## Subdivision Comments

Date: 6/29/2021

RE: SPF-21-00002

**ZIPPERER SHORT PLAT, SP-20-00005  
 SPF-21-00002**

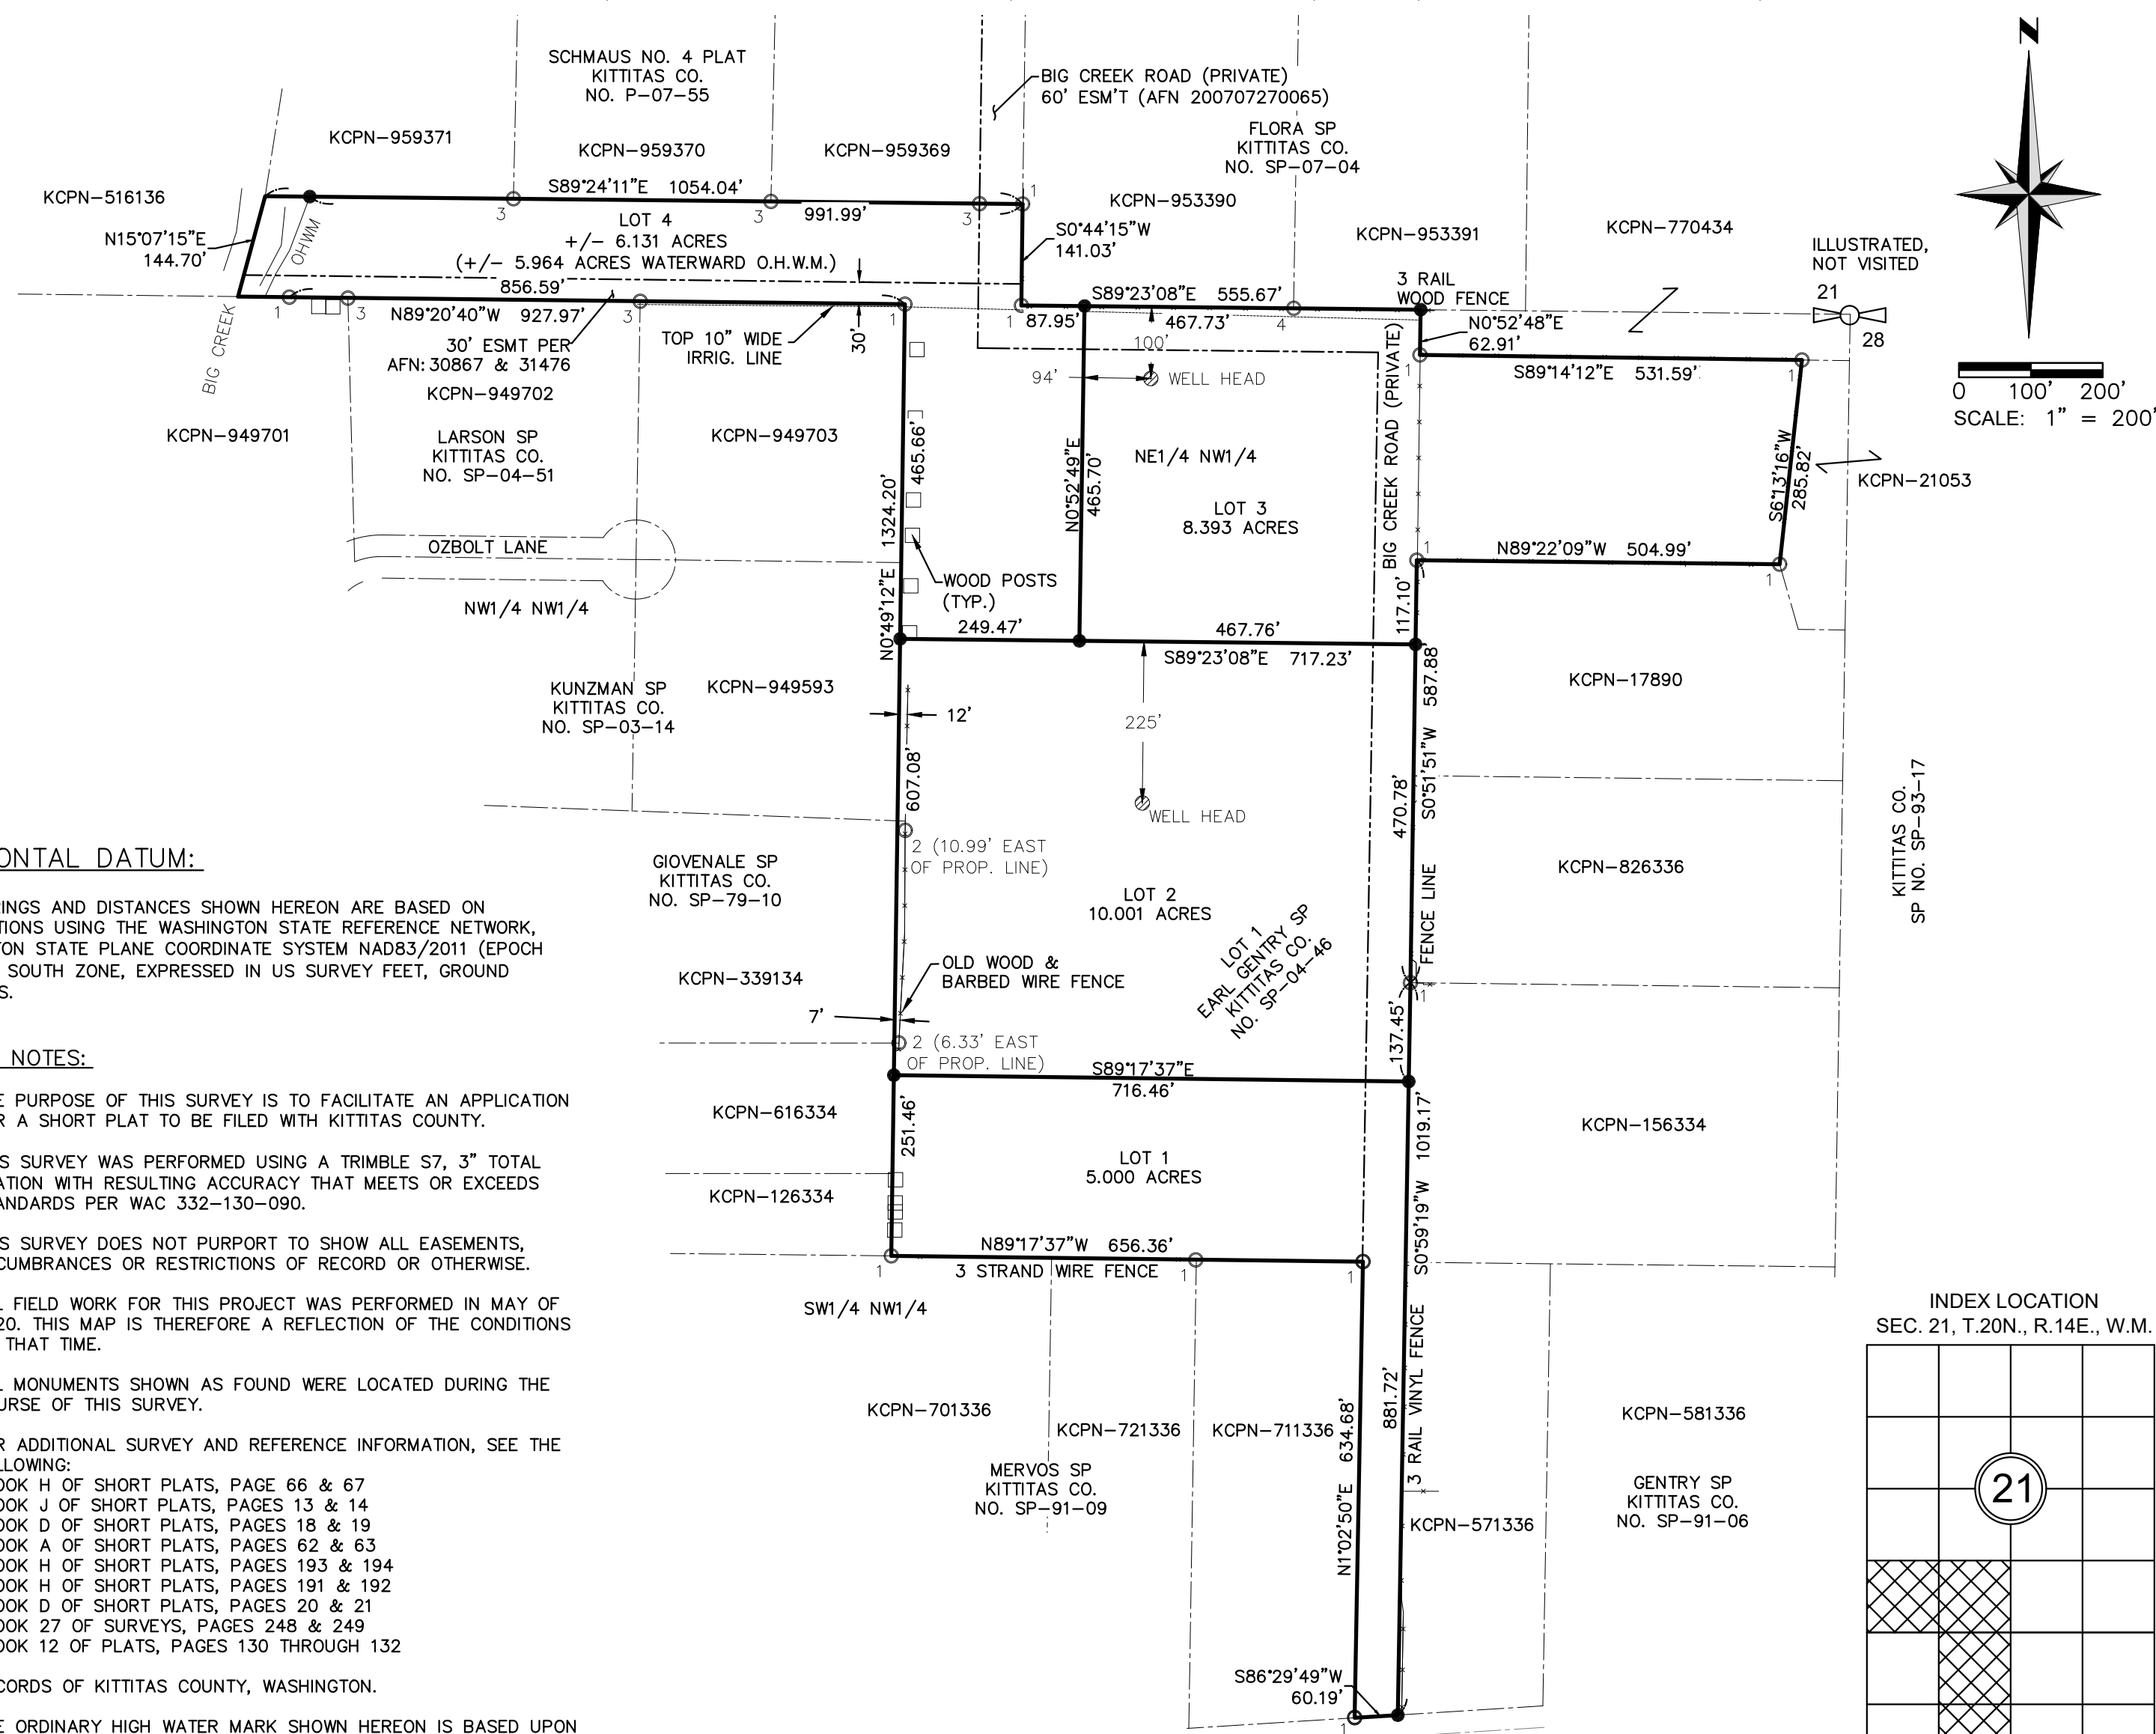
**B-3** Noted in previous preliminary findings well setbacks need to be maintained. Current site plan is still needing to indicate current setback from proposed drilled wells and proposed boundary line. before final approval from the Health officer site plan should have well locations showing that the 50ft setback will be maintained. Another option would be to provide supporting documentation (an approved Group B workbook.) showing that existing well has been converted to a group B well striking down setback requirement set by KCC 13.20.040.
